{In Archive} Planning Re-Consultation on: Y/184/21/DOC

Engineers Comments Regarding Condition 8

Drainage Construction Details Proposed Basin Detail Sheet 1 of 2

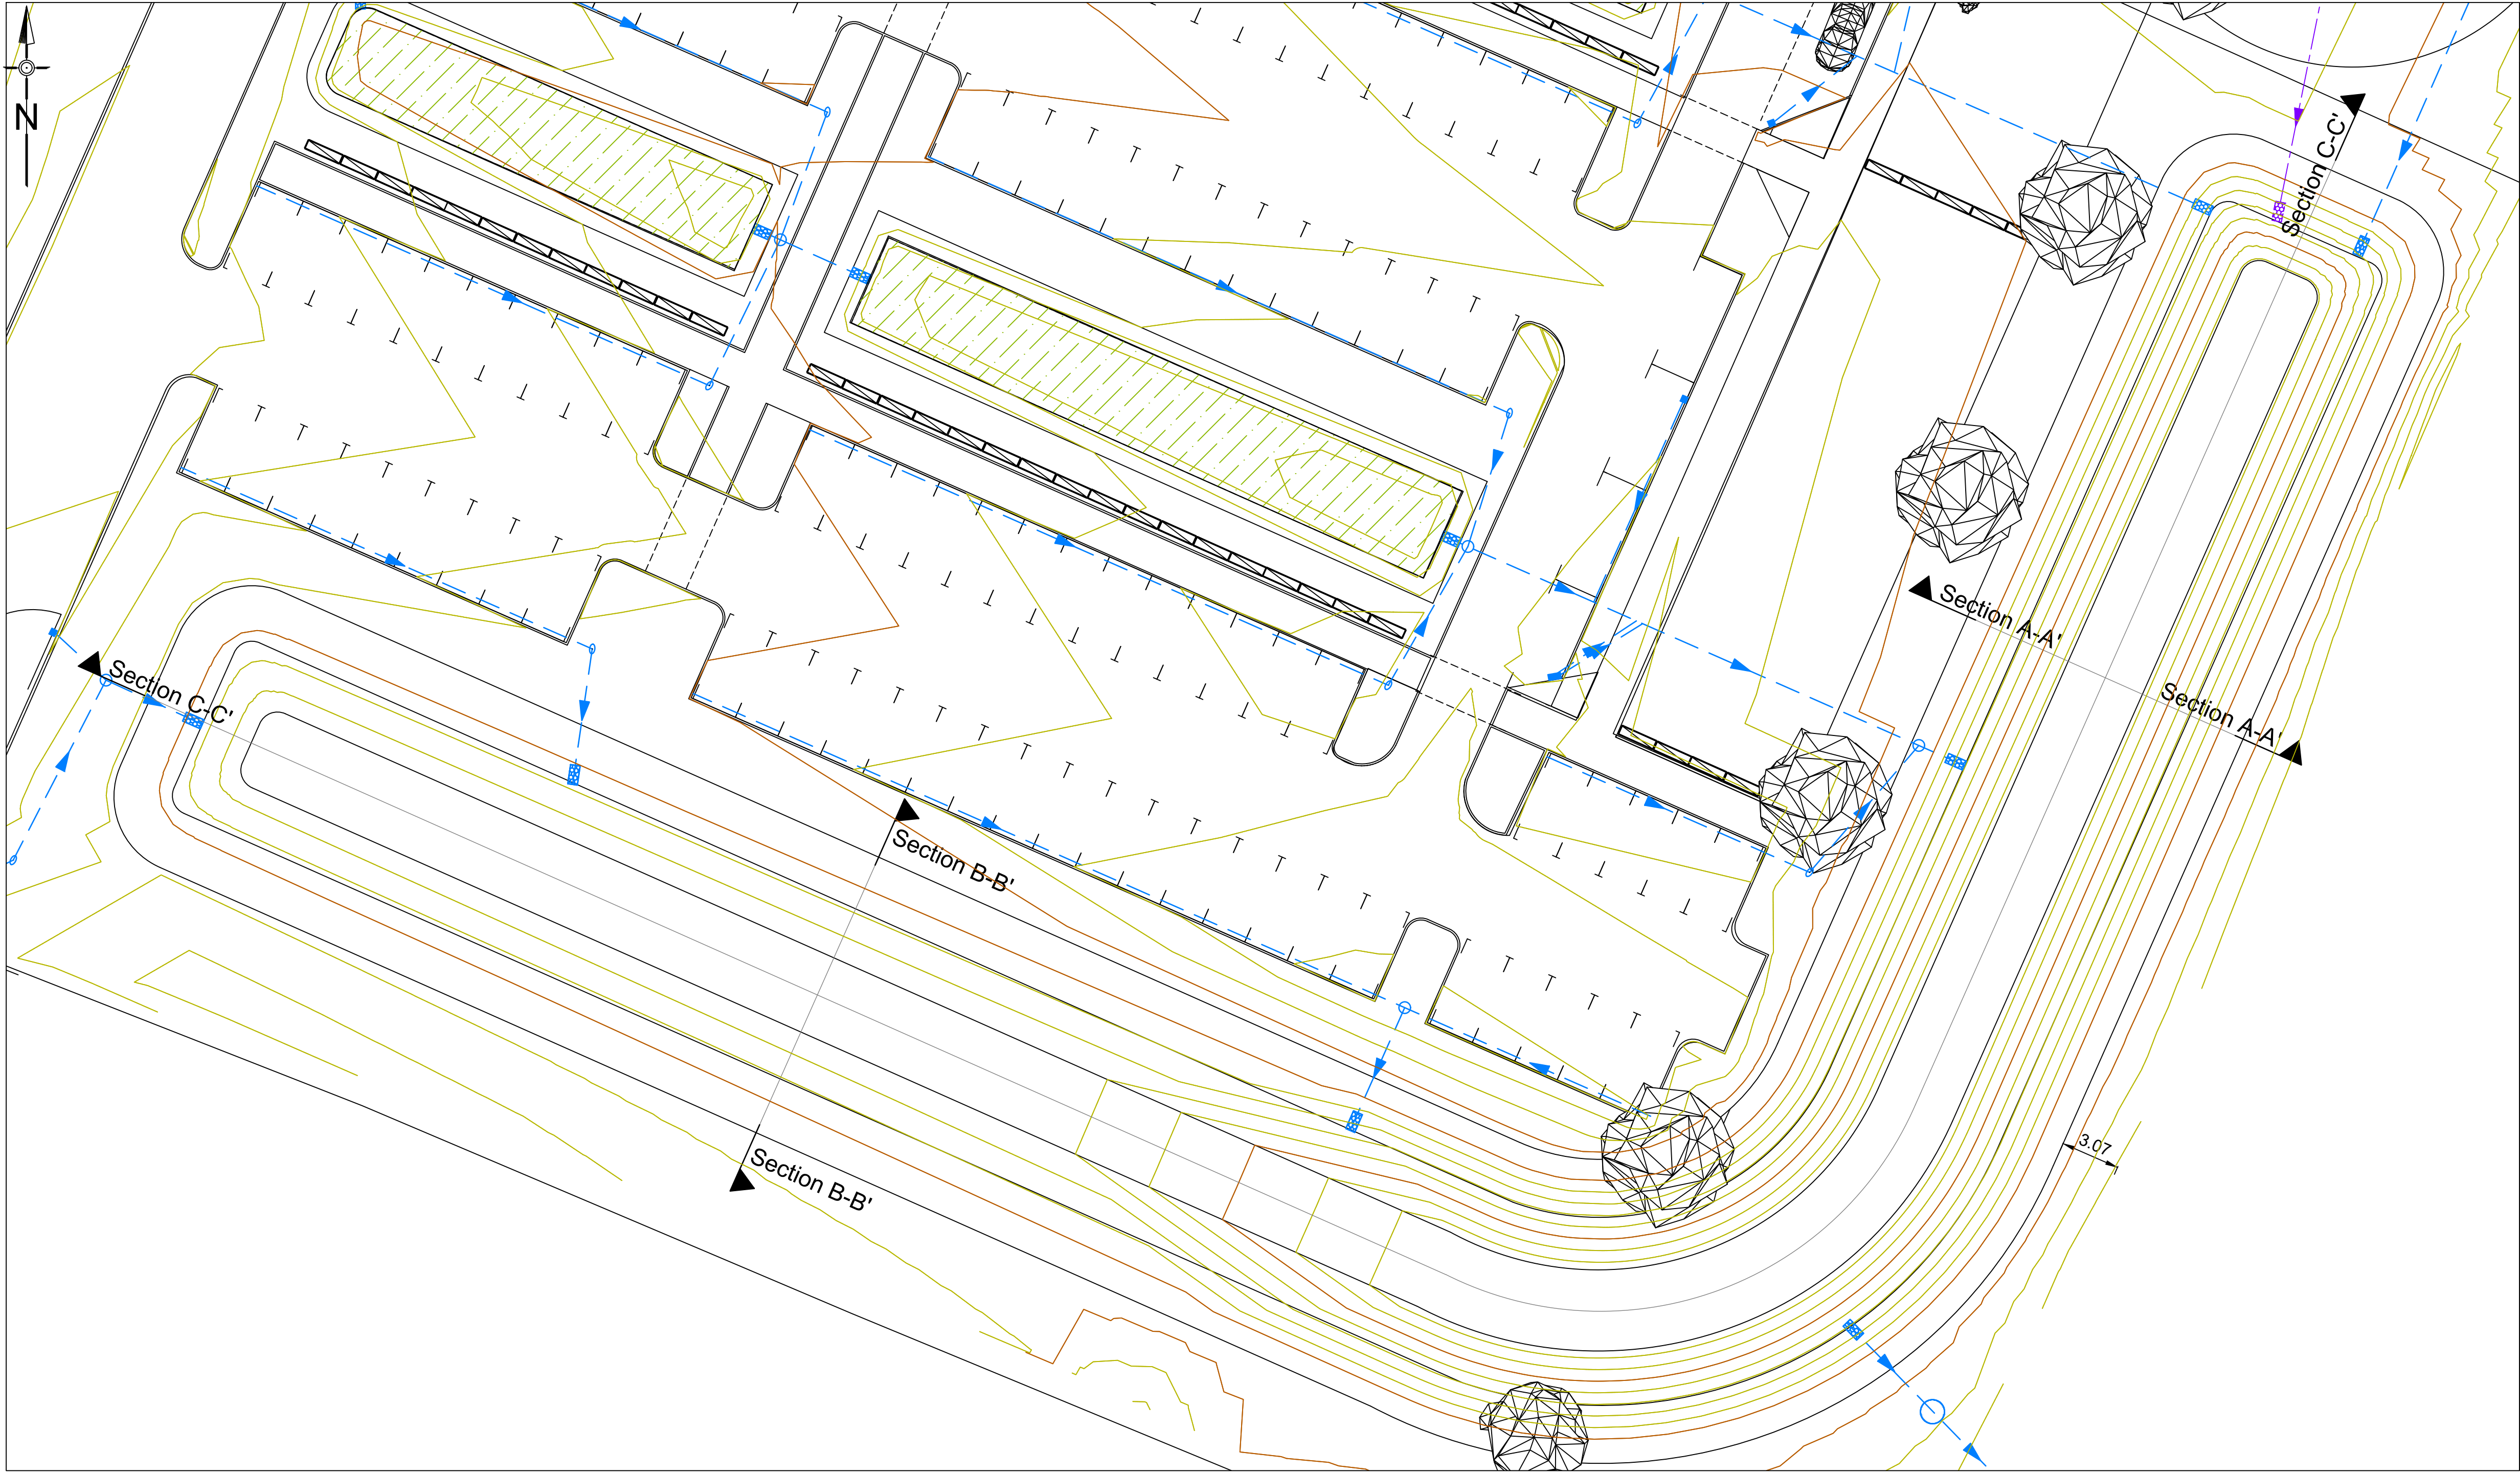
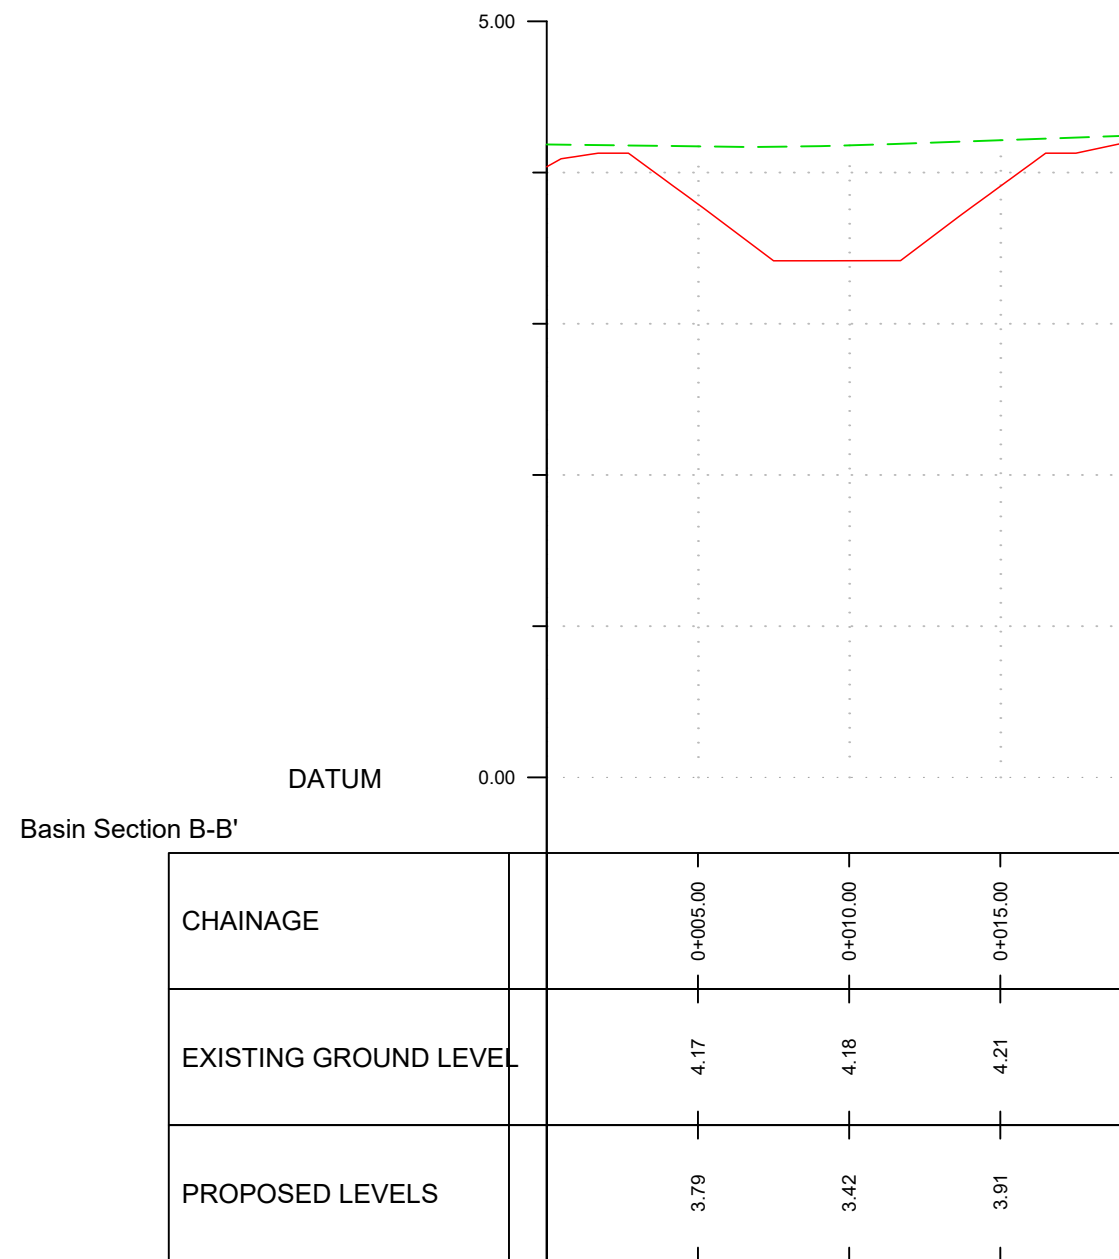
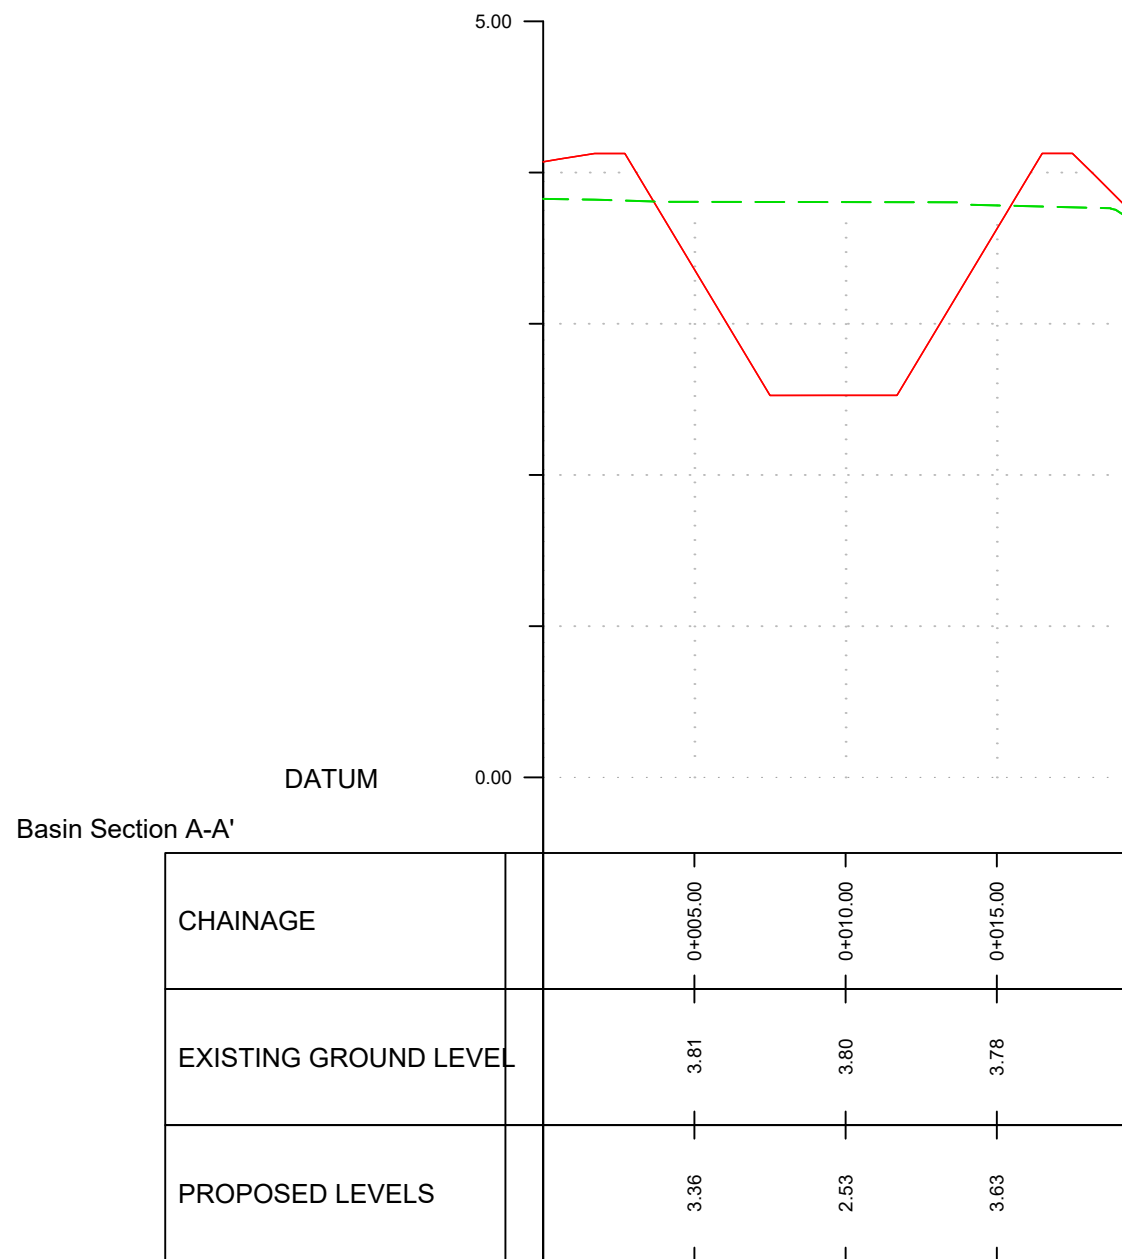
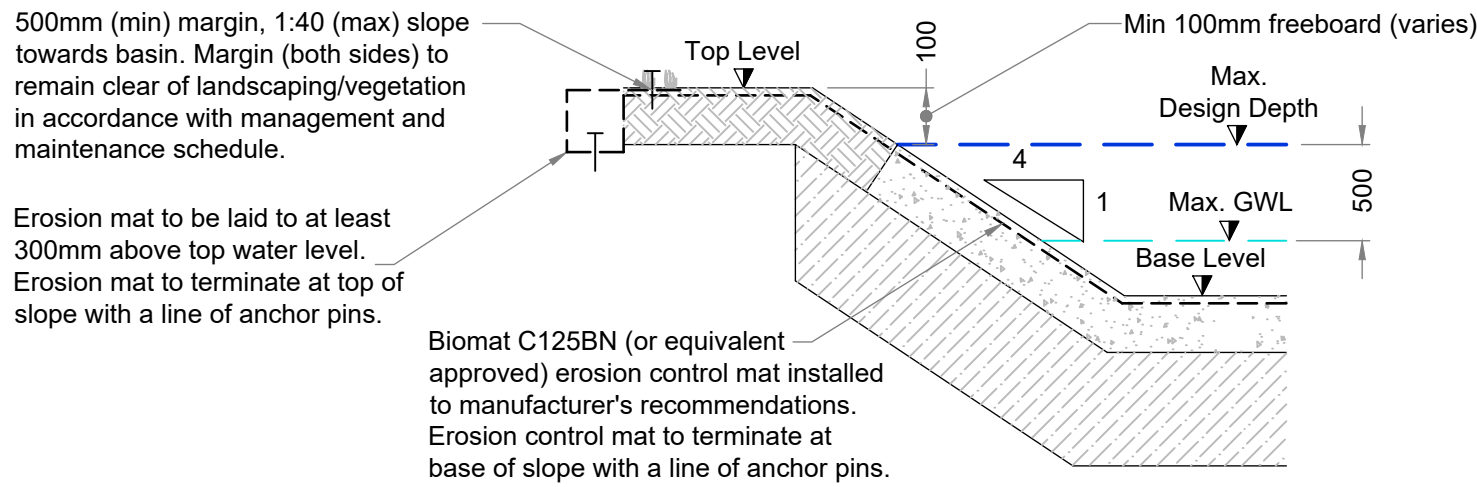
As per WSCC policy for the management of surface water policy 1- design must follow the hierarchy for sustainable drainage. Locations of groundwater monitoring and infiltration testing have not been provided. It is noted that groundwater was found to peak at circa 1m depth. Shallow infiltration testing was completed and gave rates which do not preclude the use of infiltration. Please supply evidence why the sole use of infiltration is not acceptable

here. E.g. a design with infiltrating permeable paving, swales and shallow infiltration basin.
A full review of responses to our other comments has not been completed as this
fundamental issue must be addressed first before reviewing details.
Kind regards,

As noted from the test results, the lowest value is 2.37×10^{-6} m/s, which when the appropriate factor of safety (in this case the lower factor of safety in accordance with CIRIA SuDS Manual is 5 for areas greater than $1,000\text{m}^2$) is applied would yield a percolation rate of 4.74×10^{-7} m/s and at this rate no infiltration system would pass the half drainage time requirements not even for a ten year storm return period - however for absolute clarity, please see attached calculation extract demonstrating same.

As previously noted, the drainage basin (and none of the drainage features) are to be lined - i.e during summer / low groundwater table, the drainage features will allow natural dispersal by infiltration. The drainage basin has been designed assuming worst case scenario that ensures sufficient buffer for drainage in all scenarios and is fully compliant with the requirements under NPPF. In effect there is over provision of storage within the drainage features to cater for the worst case scenario.
